Your Ref: OWPC18196
Our Ref: M/41/18/HH 22-03-2018
Please ask for:
Zac Denton

Extension to 1st floor incorporating rooms within the roof space for new 2nd floor & single storey rear extension with balcony above.

25 Sea Way Middleton-On-Sea

PROPOSED ELEVATIONS

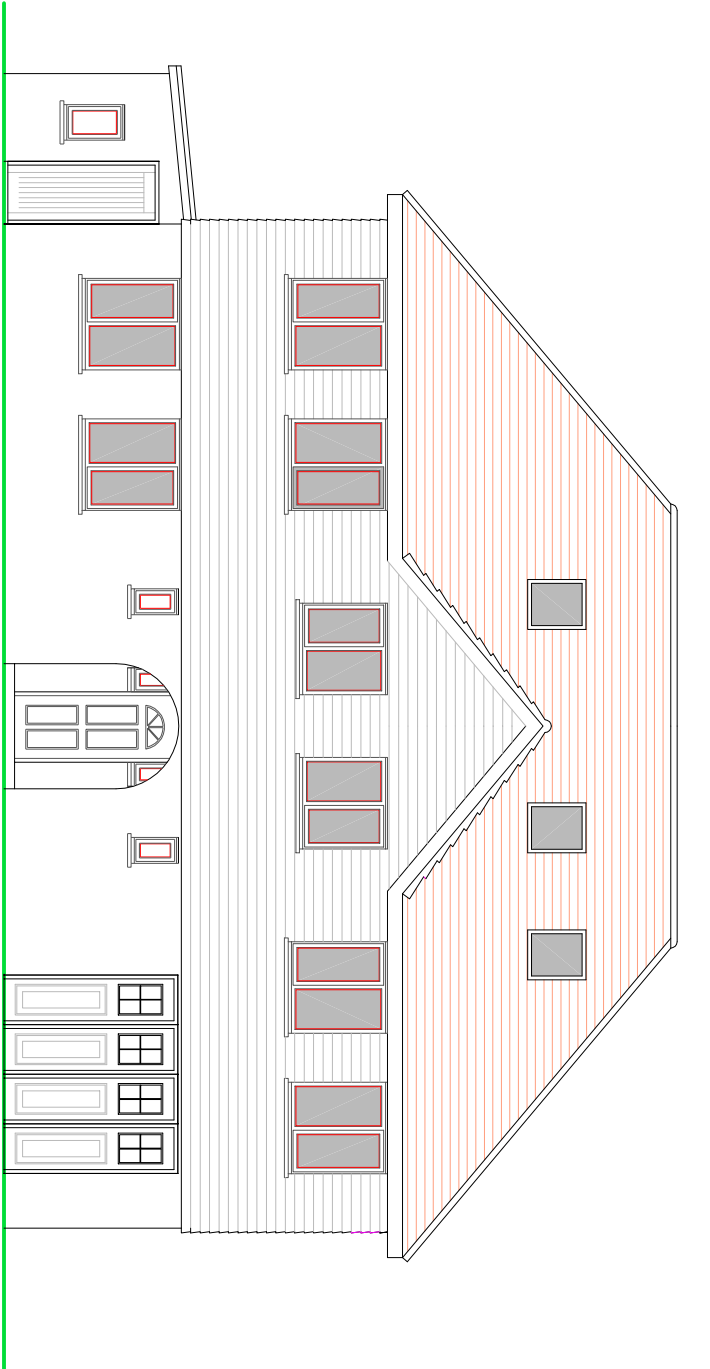
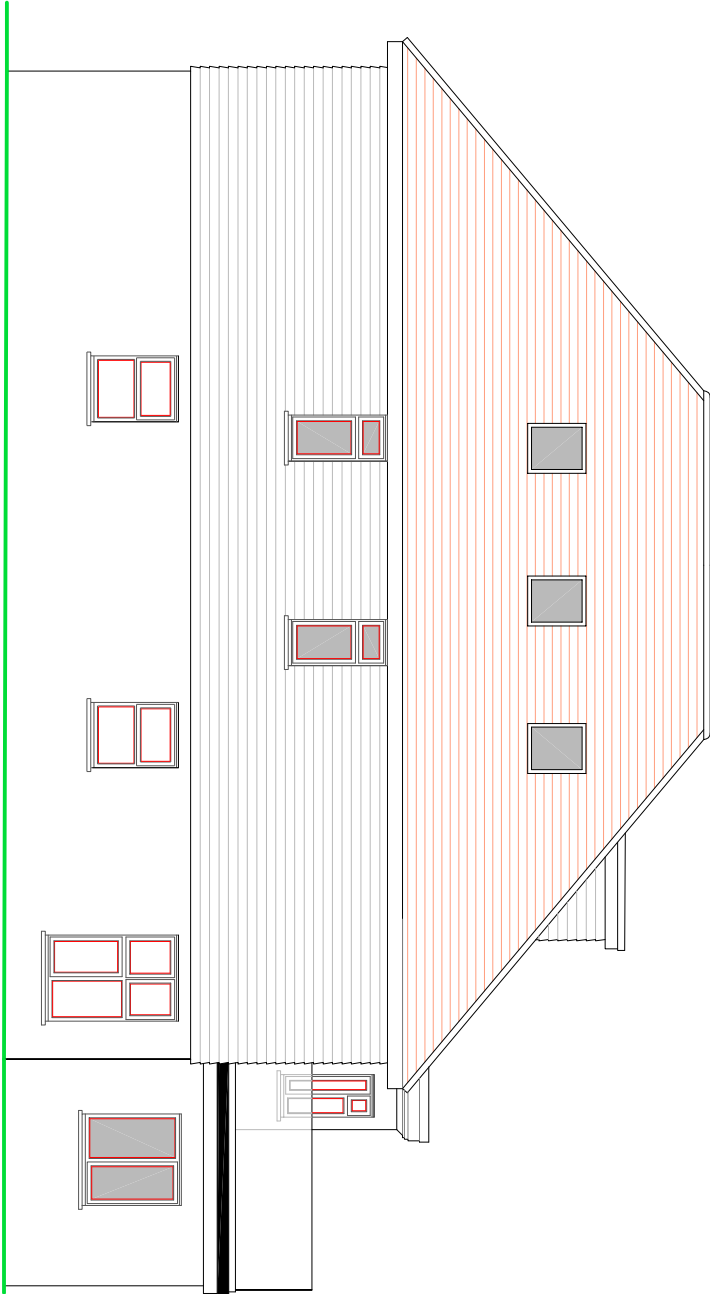
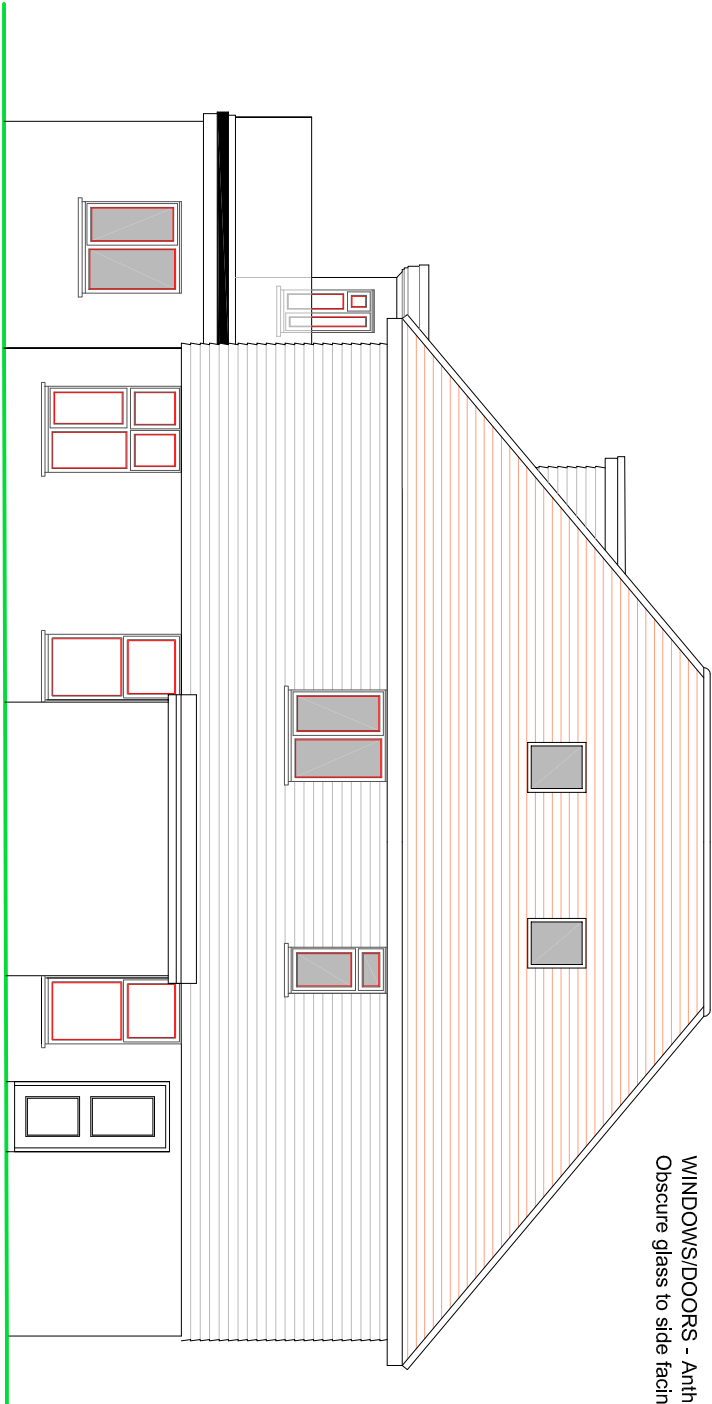
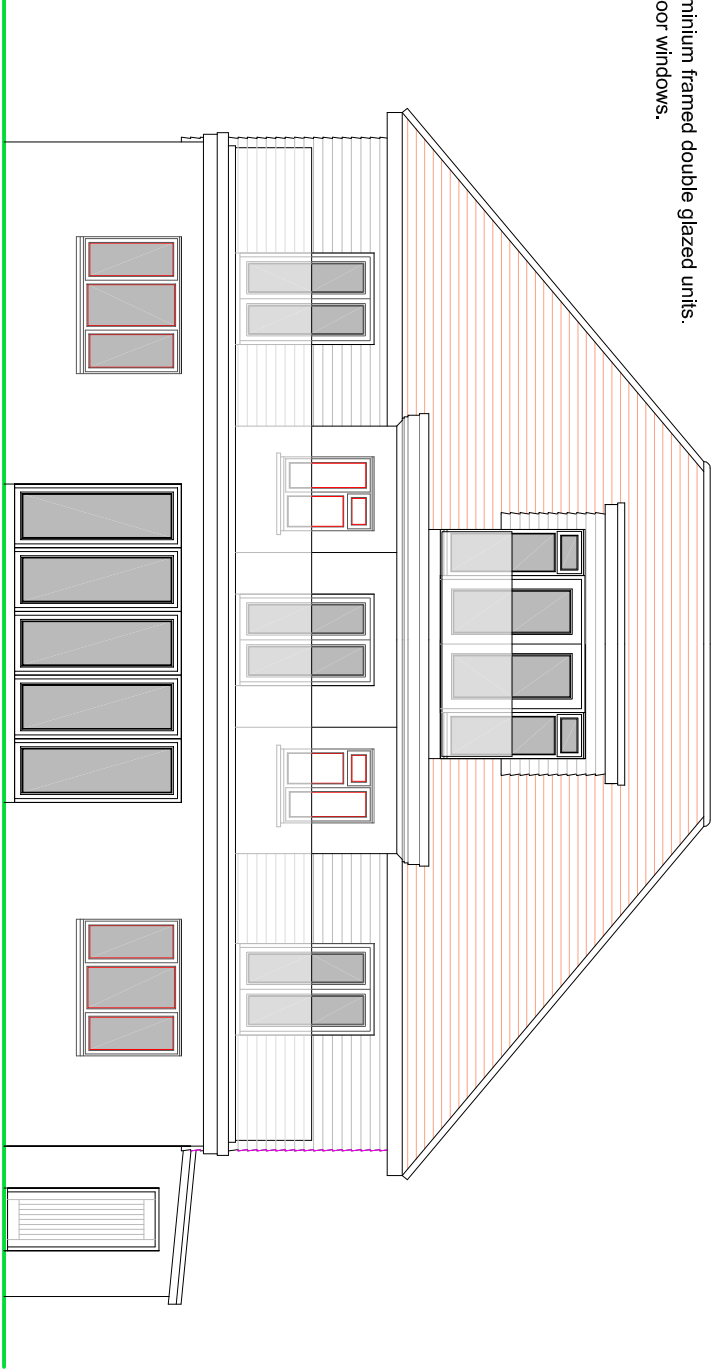
Please continue to uphold Supplementary Planning Guidelines, and show consistency in making decisions by refusing this current application, which includes an intrusive third floor dormer and balcony, which would have a detrimental effect on the locality if allowed.
